Charlotte Department of Transportation

Memorandum

Subject: Rezoning Petition 08-084: Located on the north side of Equipment Drive
between Jeremiah Road and Mineral Springs
Road

SHEET TITLE:
**OVERALL
CONDITIONAL
DEV'T PLAN**

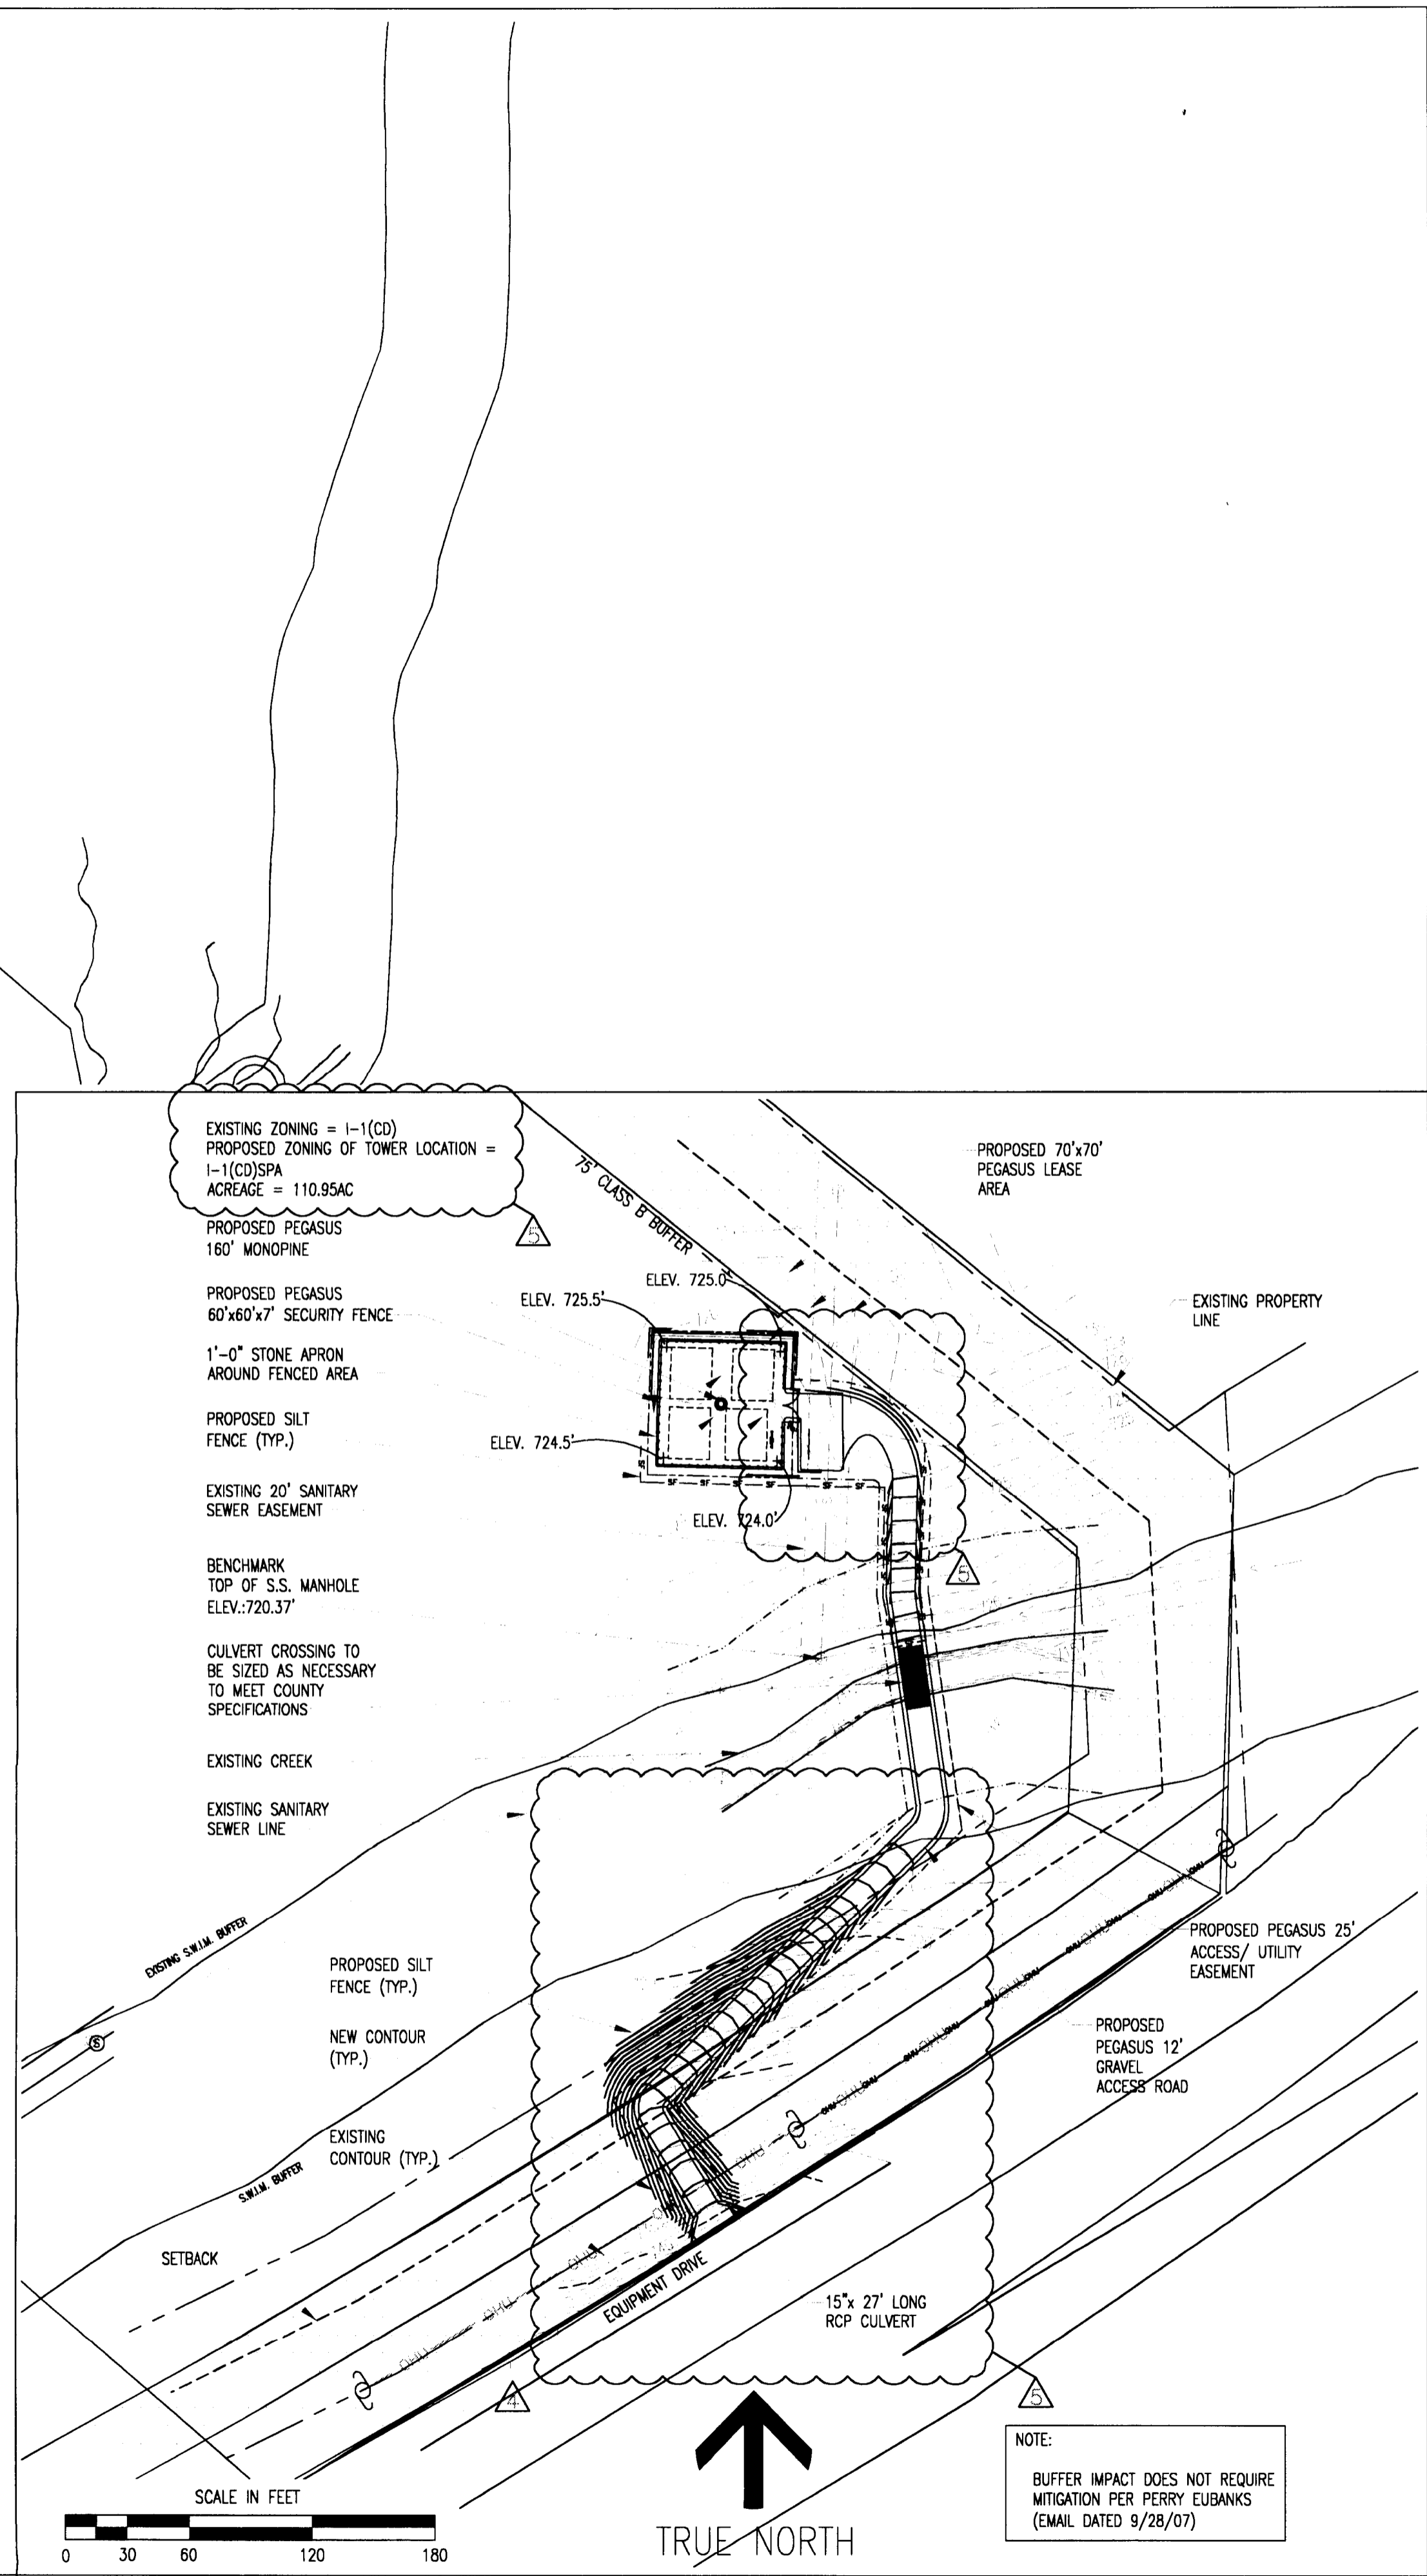
1. The driveway needs to intersect Equipment Drive perpendicularly and not at a skew as shown.

Adequate sight triangles must be reserved at the proposed street entrances. Two 10' x 70' sight triangles are required for the entrance(s) to meet requirements. All proposed trees, berms, walls, fences, and/or identification signs must not interfere with sight distance at the entrance(s). Such items should be identified on the site plan.
